Application ref: **P/175/25/DOC**

Description: Approval of details reserved by condition imposed under P/139/22/RES relating to condition 6-Mitigation Landscape Phasing Plan.

Location: Church Barton House Horns Lane Pagham PO21 4NZ

Summary recommendation: Recommend **discharge of Condition 6** - Mitigation Landscape Phasing Plan on this P/175/25/DOC application reserved by condition imposed under P/139/22/RES

Detailed Planting Plan
Sheet 1 of 5

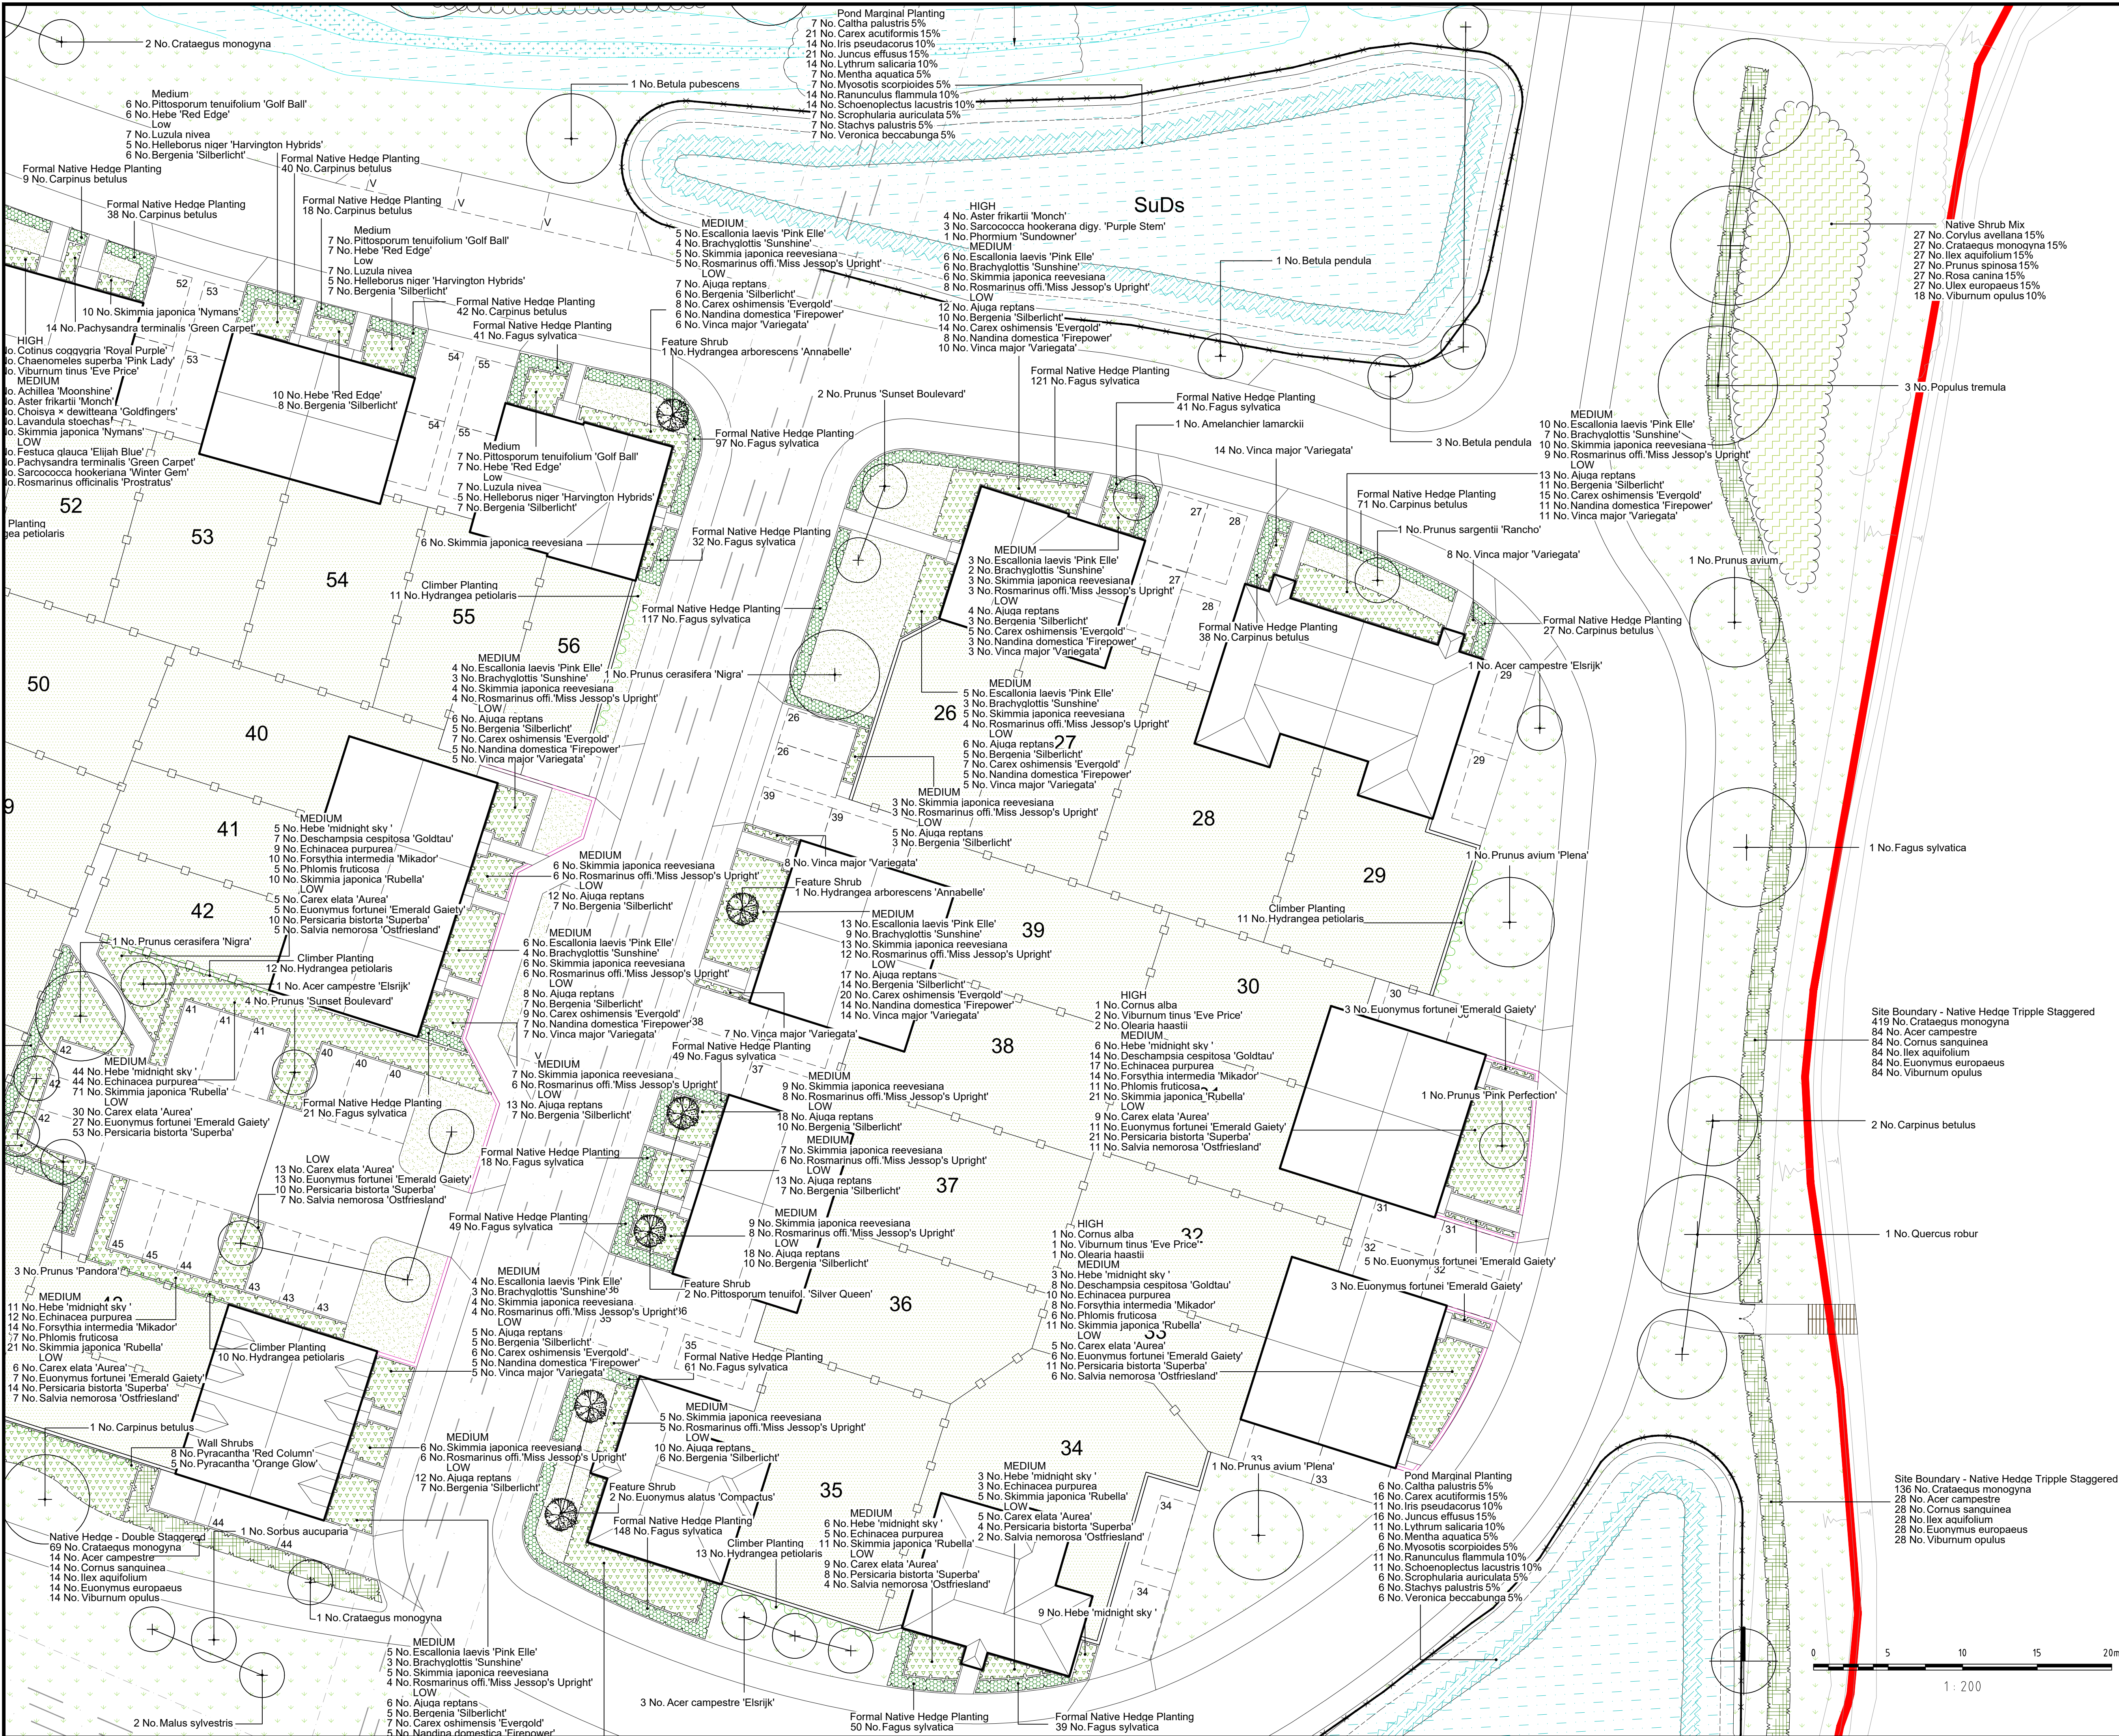
The mitigation landscaping includes native woodland planting, meadow grassland, wetland grassland, double/triple staggered native hedgerows, trees and a dog-proof fencing. It is noted that the planting of the double/triple staggered native hedgerow in particular (and any proposed trees within that hedgerow) is what needs to be planted prior to any construction works taking place, so that it has time to establish. This approach has been decided so that the hedgerow and trees can provide a visual screen of the development prior to occupation and together with the fence provide a physical deterrent for dogs and people using the neighbouring fields where Brent Geese have been recorded.

It should also be noted that a comprehensive maintenance and replacement planting program for the hedge should be imposed not only *for any parts that die, be damaged or removed to facilitate works*, but also due to any general failure to ensure establishment of said hedge to the timeframe proposed.
